**KIRKLEES METROPOLITAN COUNCIL
INVESTMENT & REGENERATION SERVICE**

DELEGATED DECISION TO DETERMINE PLANNING APPLICATIONS

Reference No:	2024/62/91501/W
Site Address:	16, Nabbs Lane, Slaithwaite, Huddersfield, HD7 5AU
Description:	Erection of front porch (within a Conservation Area)
Recommending Officer:	Molly Storer

DECISION – REFUSED

Drawing Title  
**EXISTING AND PROPOSED PLAN AND FRONT ELEVATION**

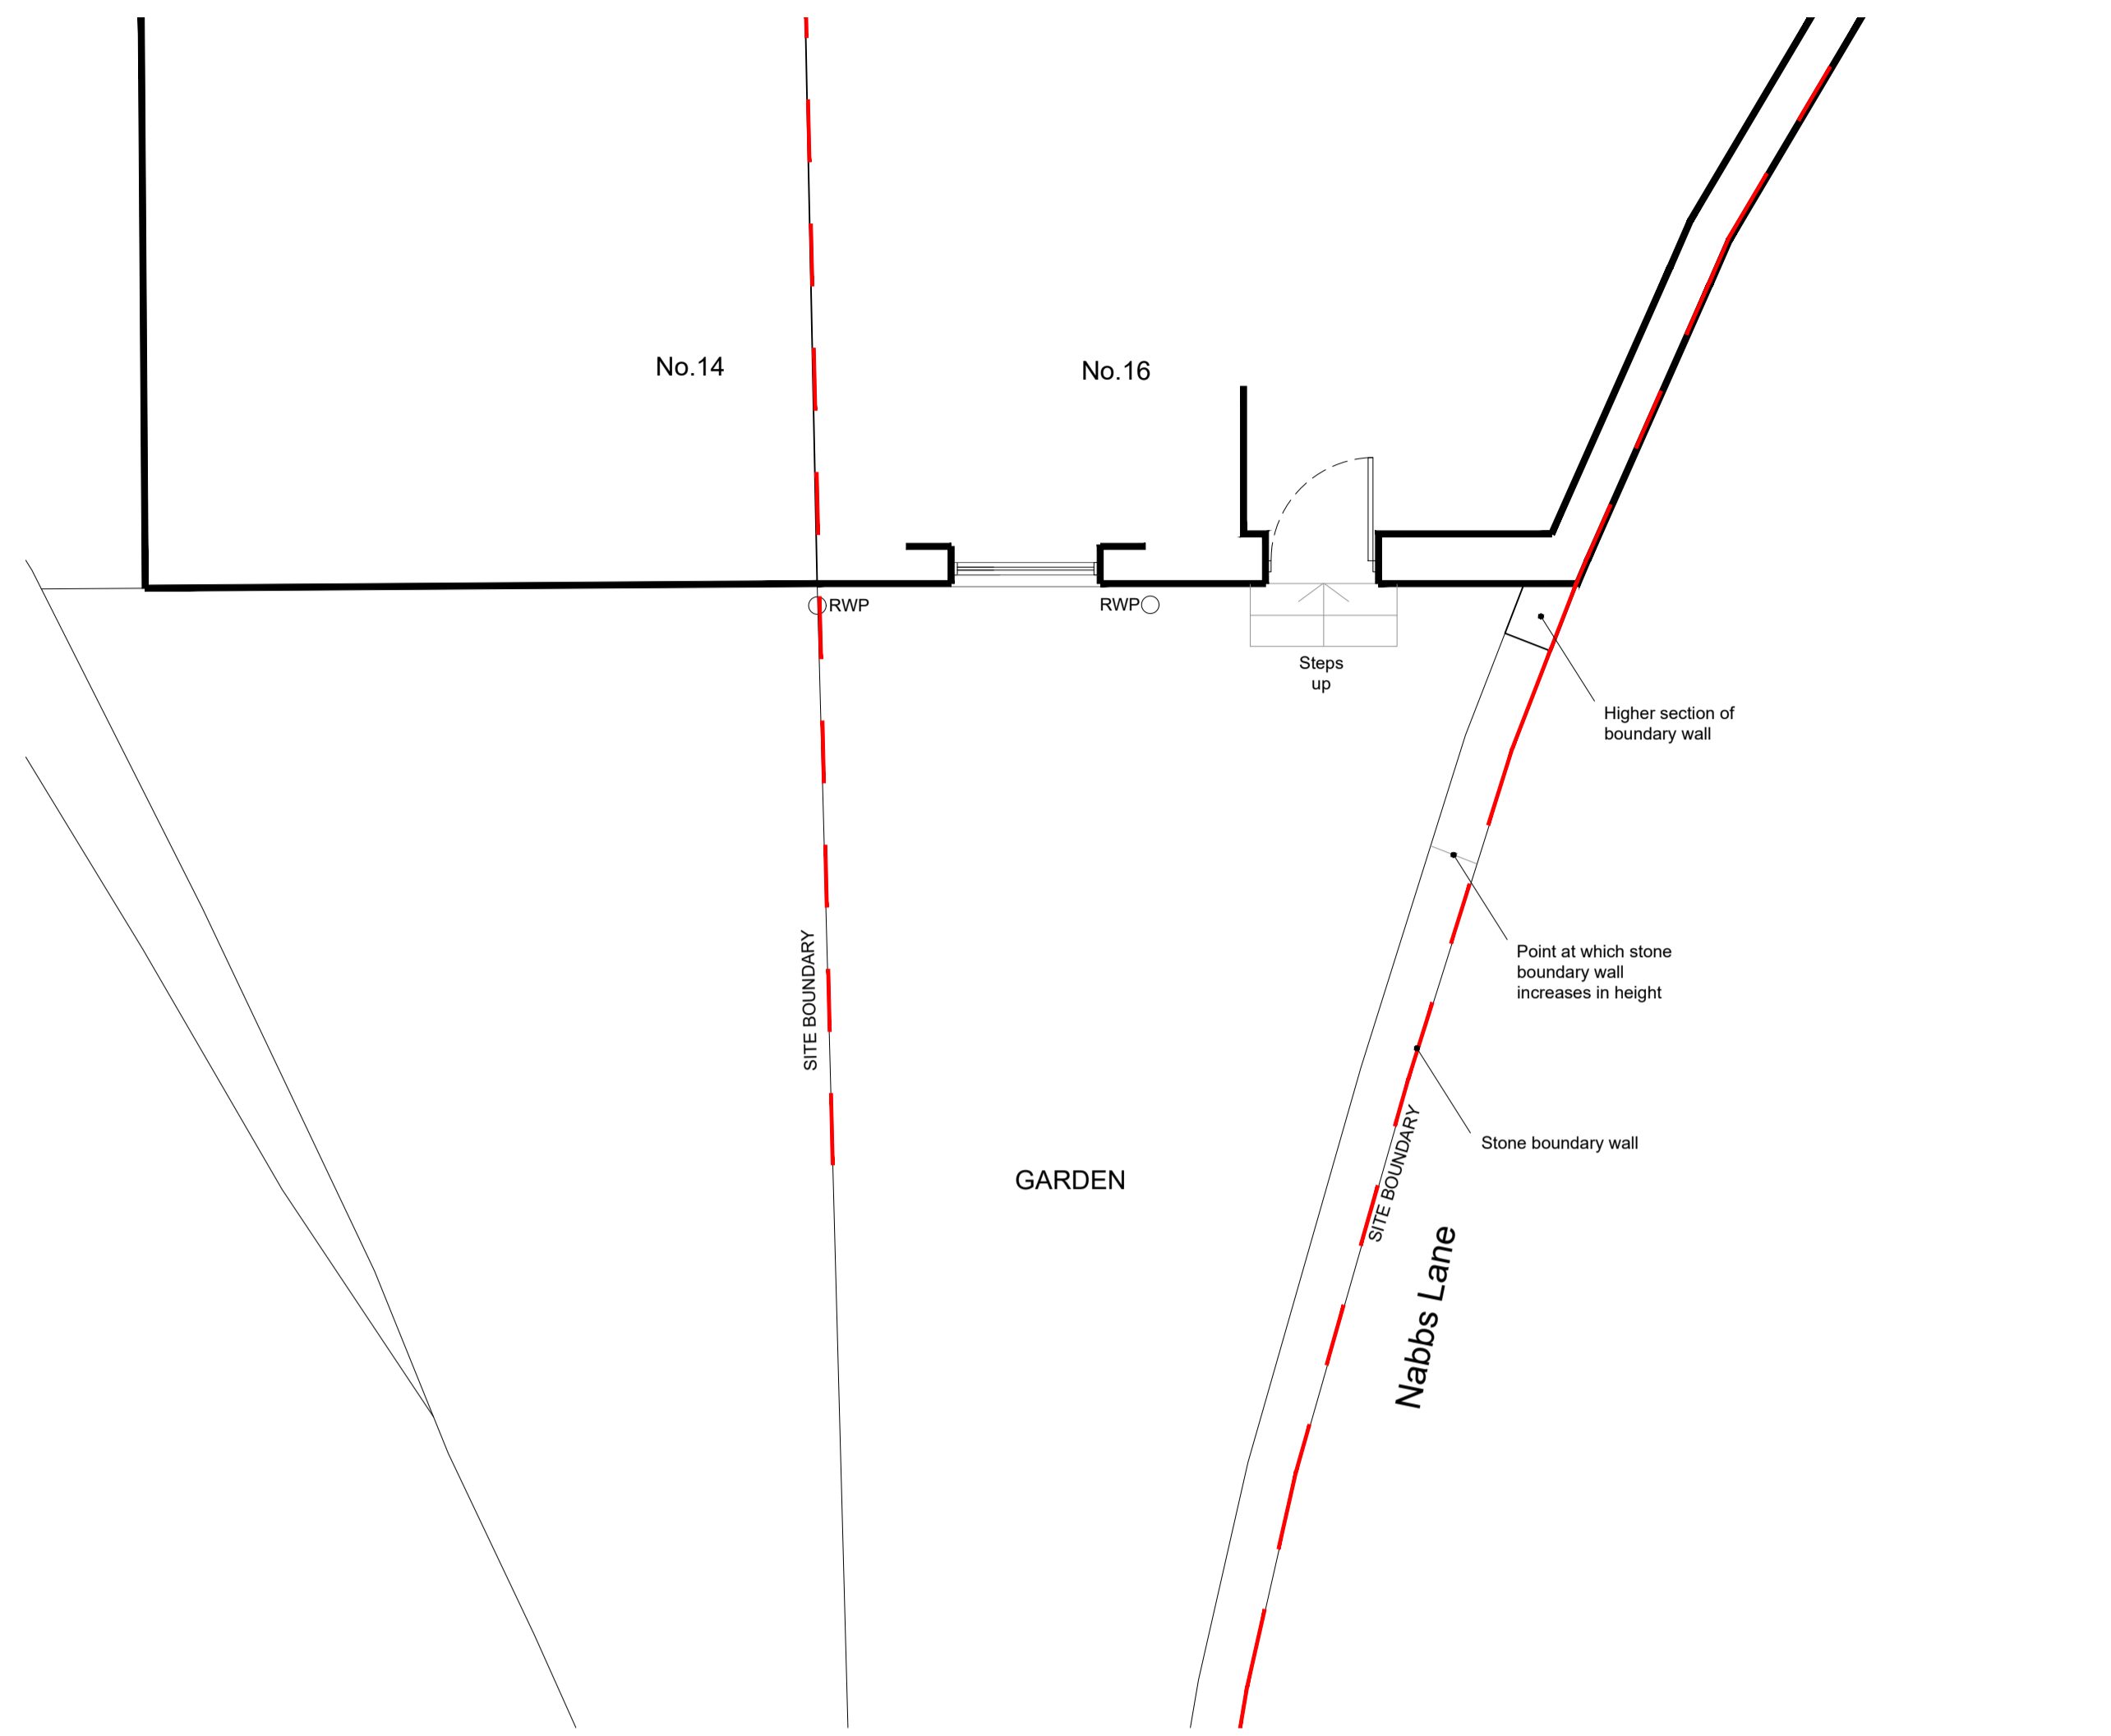
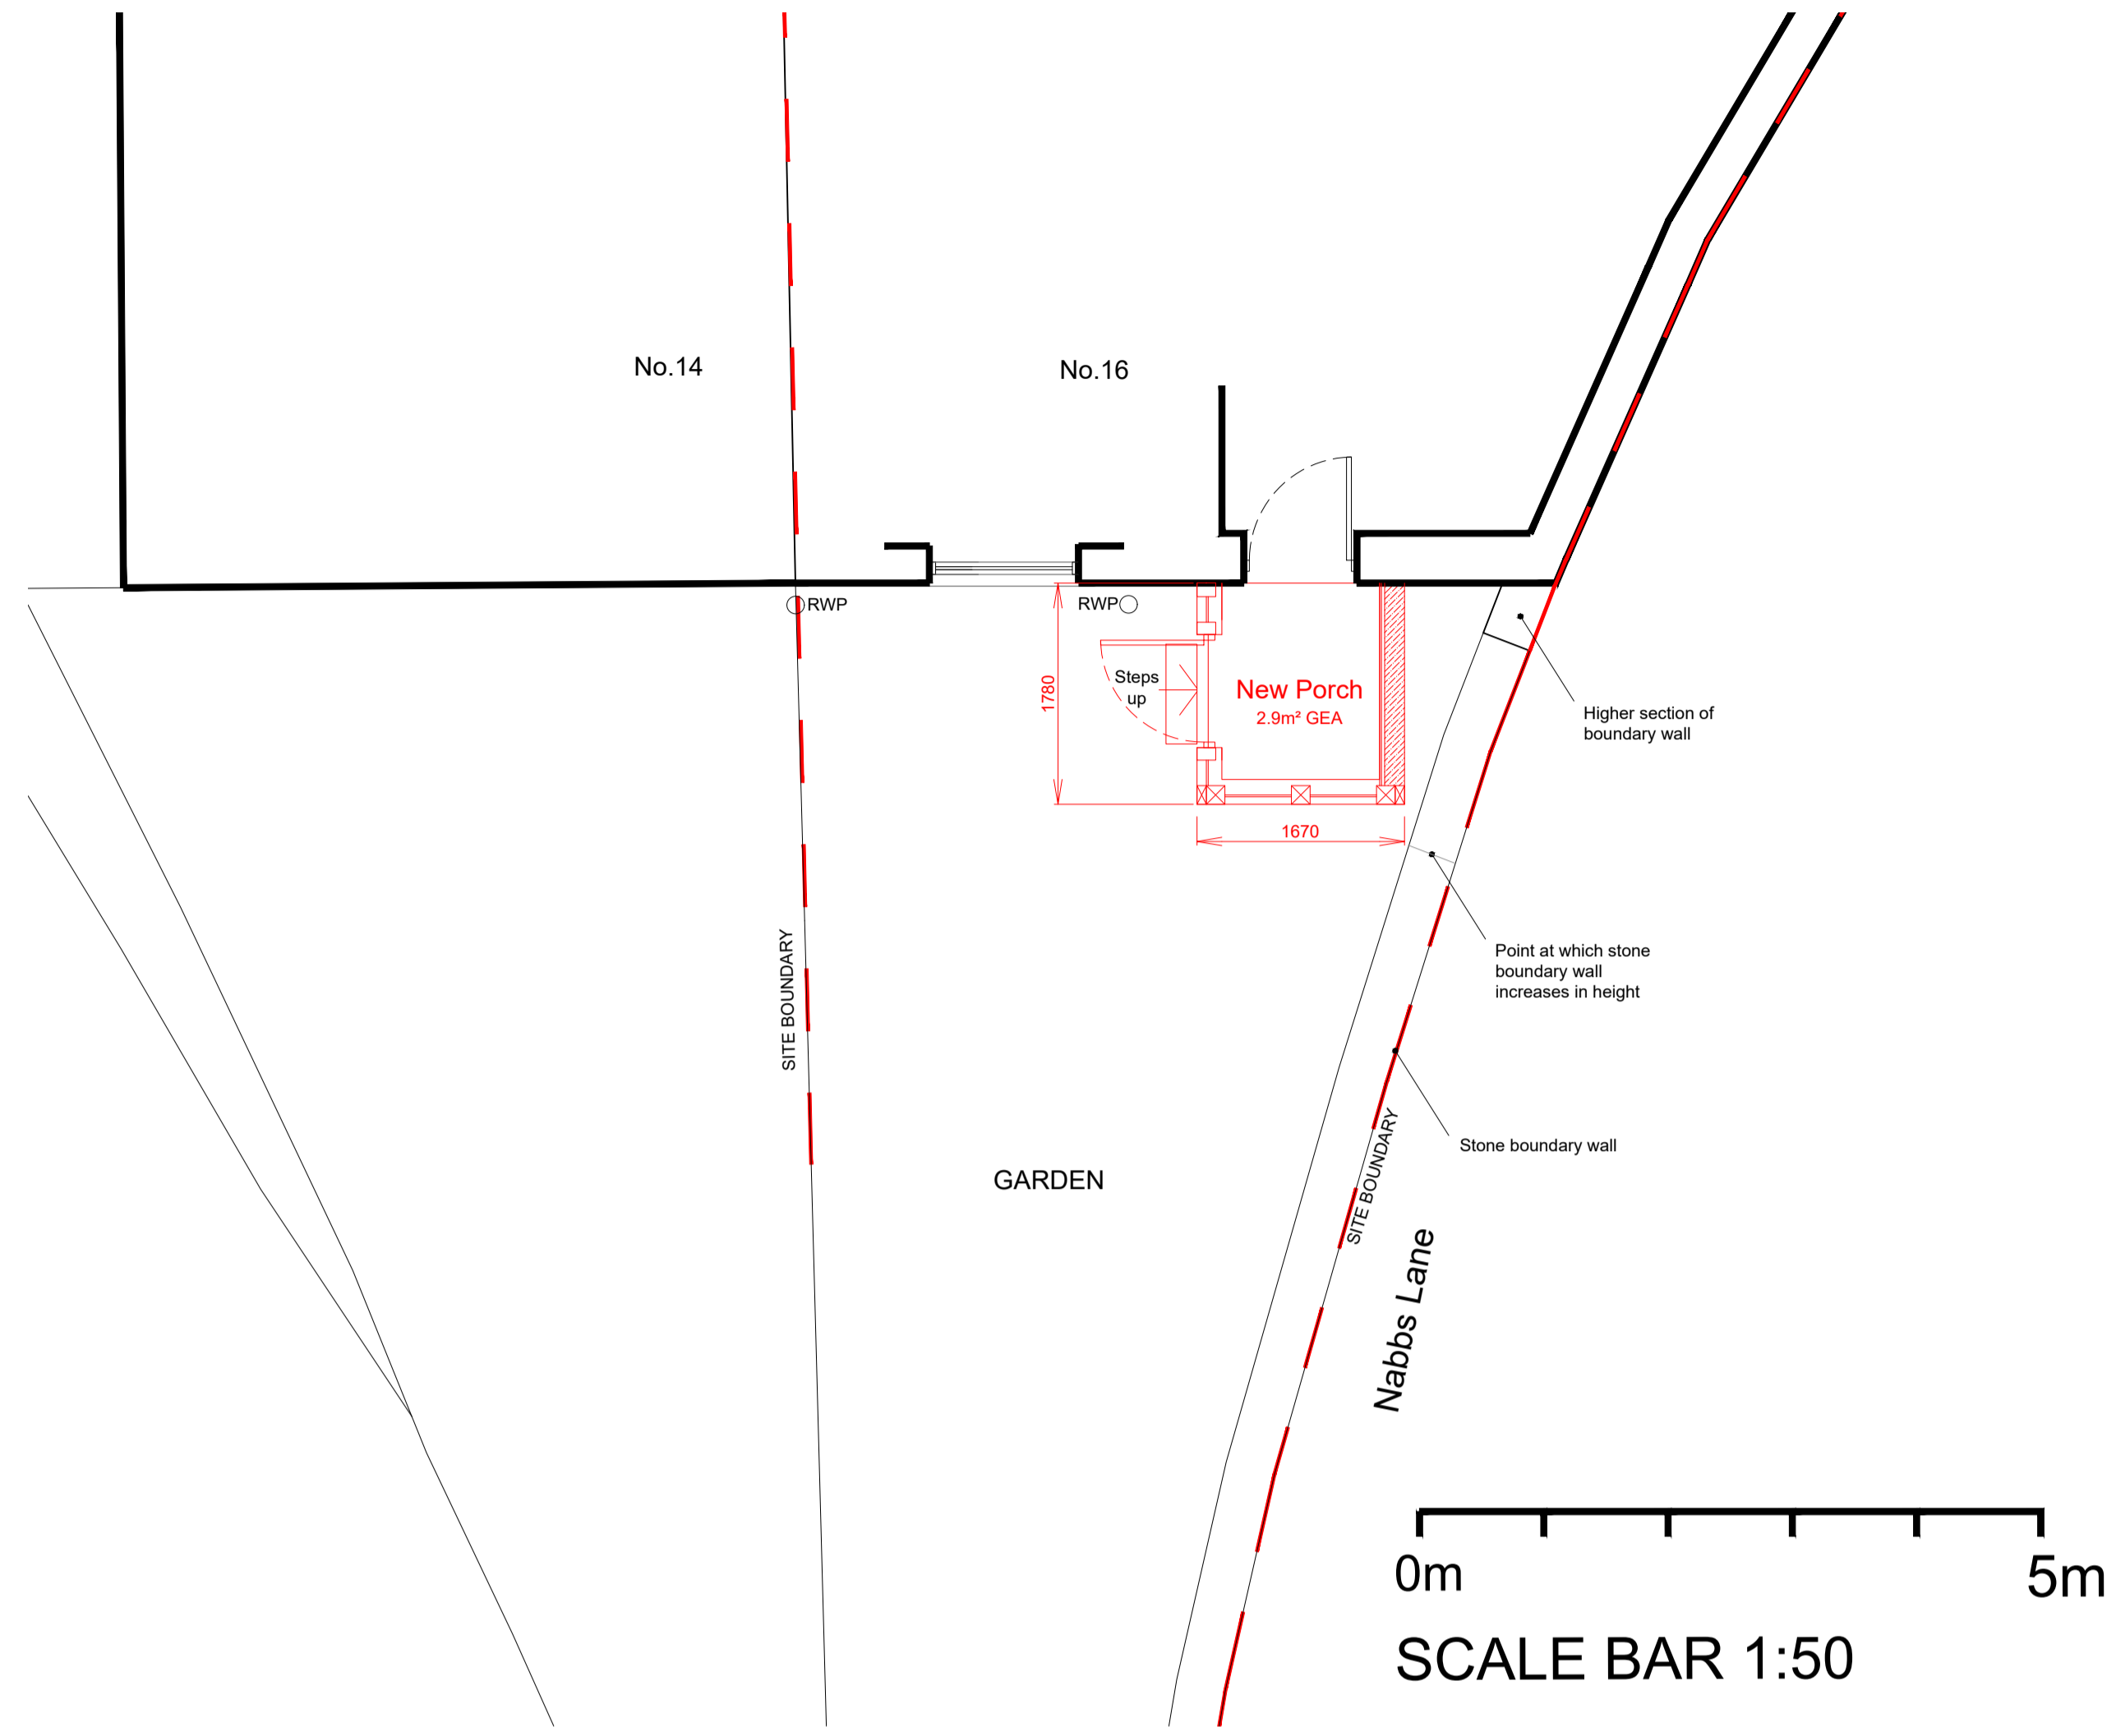
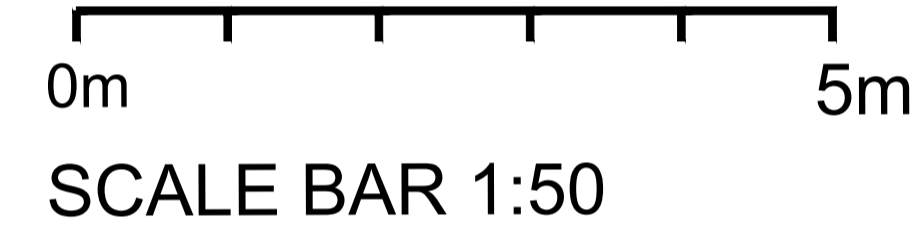
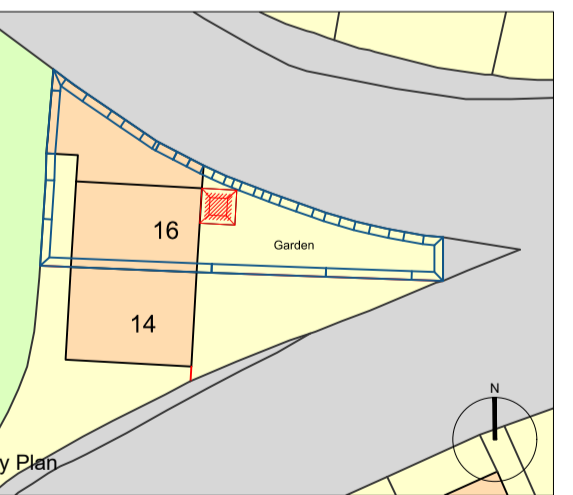
The conservation Team have been stated in their consultation response regarding the development that the substantial porch structure obscures the doorway up to the height of the moulding and disrupts the symmetry of the elevation by introducing a large dual-pitched structure on this otherwise low-key elevation. They go on to set out that the development is highly visible when viewed from the east from both Nabbs Lane and Howgate Road, due to its position to the right of the façade, the elevated position and the low

boundary wall of the front garden. The materials – a heavy oak frame and expanse of glazing, are considered to be out of character with the local vernacular by the Conservation Team, whereby they point out this is typified by natural stone.

Although it is acknowledged that the extension has been designed to attempt to harmonise with the applicant property, given its location, scale and design, the enlargement appears unduly prominent within the curtilage of the house and is highly visible when viewed from the east from both Nabbs Lane and Howgate Road, due to its position to the right of the facade, the elevated position and the low boundary wall of the front garden. The development represents a poorly designed addition as the materials of a heavy oak frame and an expanse of glazing, are out of character with the local vernacular which is typified by natural stone. In addition, the porch extension does not preserve the setting of the Grade II listed viaduct directly behind the dwellings. Therefore, the addition detracts from the character of the host property and Slaithwaite Conservation Area. Furthermore, it is noted no public benefits have been submitted or are considered to be present which outweigh the harm.

1. The development, by reason of its prominent location, scale, form, materials, expanse of glazing and design has a harmful impact upon the historic character of the host property, the Slaithwaite Conservation Area and the setting of the Grade II listed viaduct. The development constitutes a visually harmful addition which does not respect or enhance the character of the townscape or designated heritage assets. There are no public benefits identified, or considered to exist more generally which justify the identified harm to the setting and character of the host property and the harm to the setting of the Grade II listed viaduct directly behind the dwellings. The development is therefore contrary to Policies LP24 and LP35 of the Kirklees Local Plan, Principles 1 & 2 of the Council's adopted House Extensions and Alterations Supplementary Planning Document, policies within Chapters 12 and 16 of the National Planning Policy Framework and Sections 66(1) and 72 of the Town & Country Planning (Listed Buildings & Conservation Areas) Act 1990.
